**CITY OF ALBUQUERQUE  
PLANNING DEPARTMENT  
October 2, 2013  
DRB Comments**

**PROJECT # 1009839**

**APPLICATION # 13-70689**

**RE: Lot 9, Los Lomas Business Park**

PLAT OF TRACTS 9-A AND 9-B LAS LOMITAS BUSINESS PARK SUBDIVISION

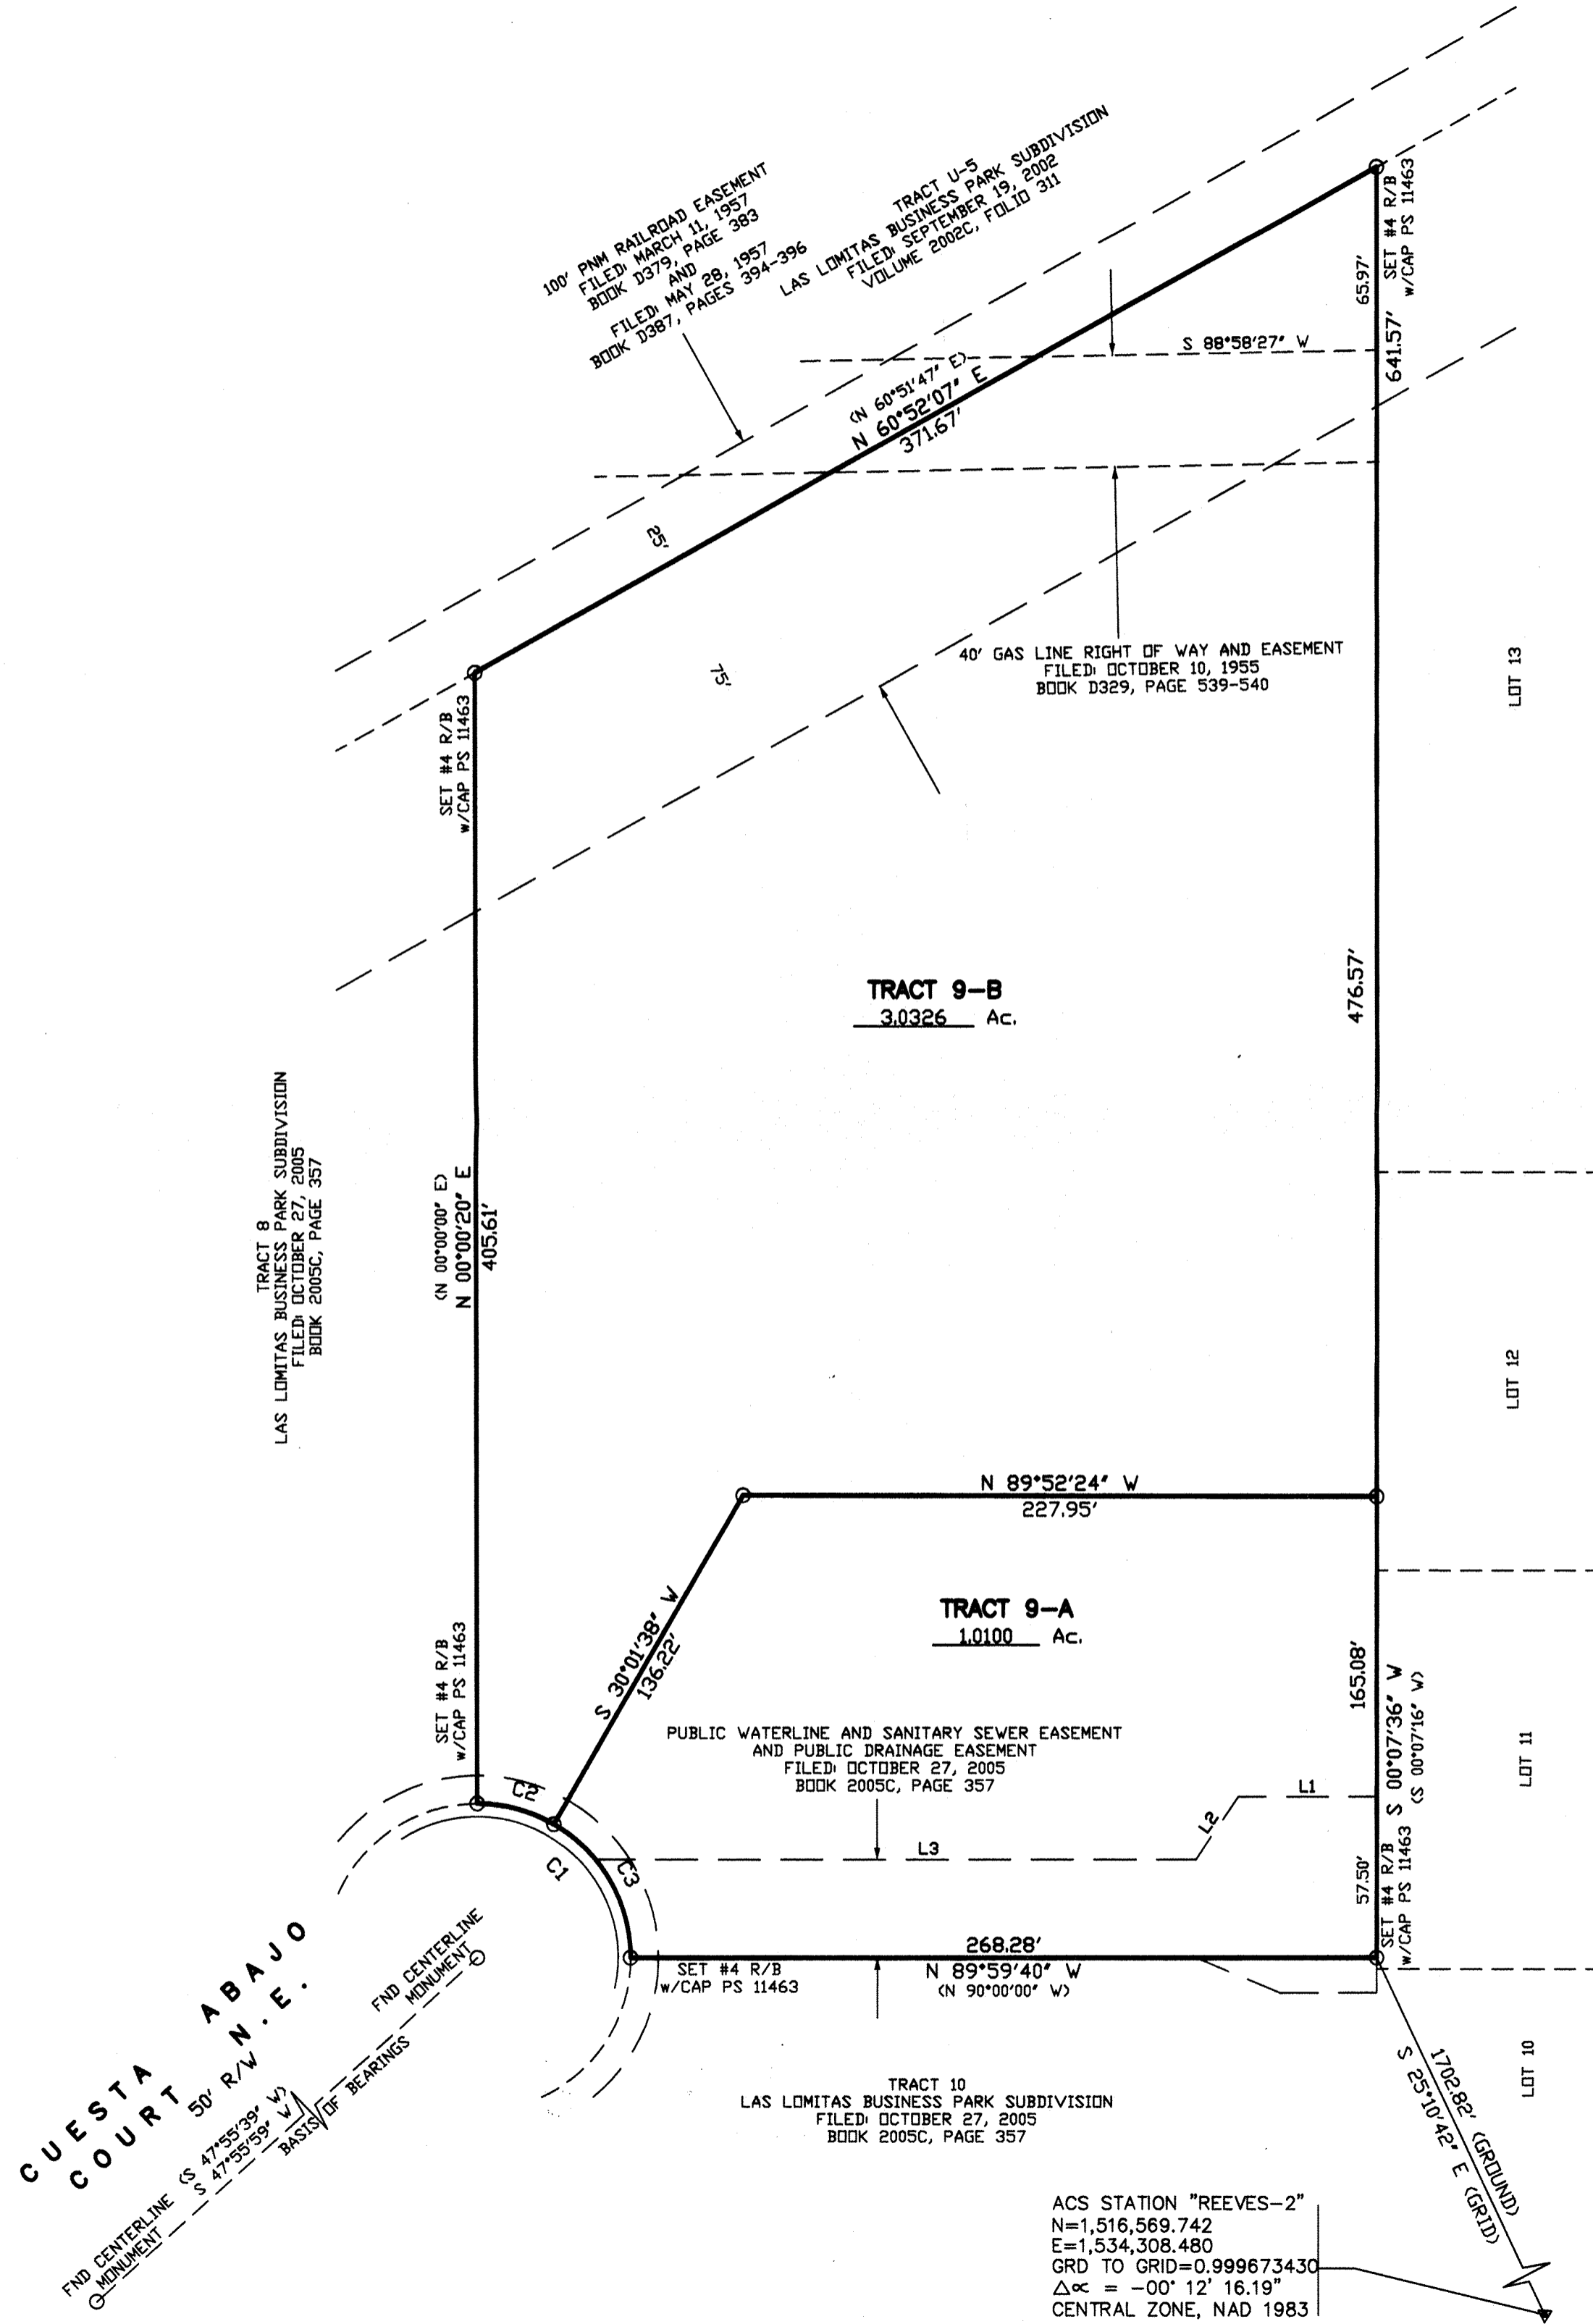
Based on the limited street frontage for existing Lot 9, a shared access easement onto Cuesta Abajo Ct NW is needed - refer to comments from Transportation Development.
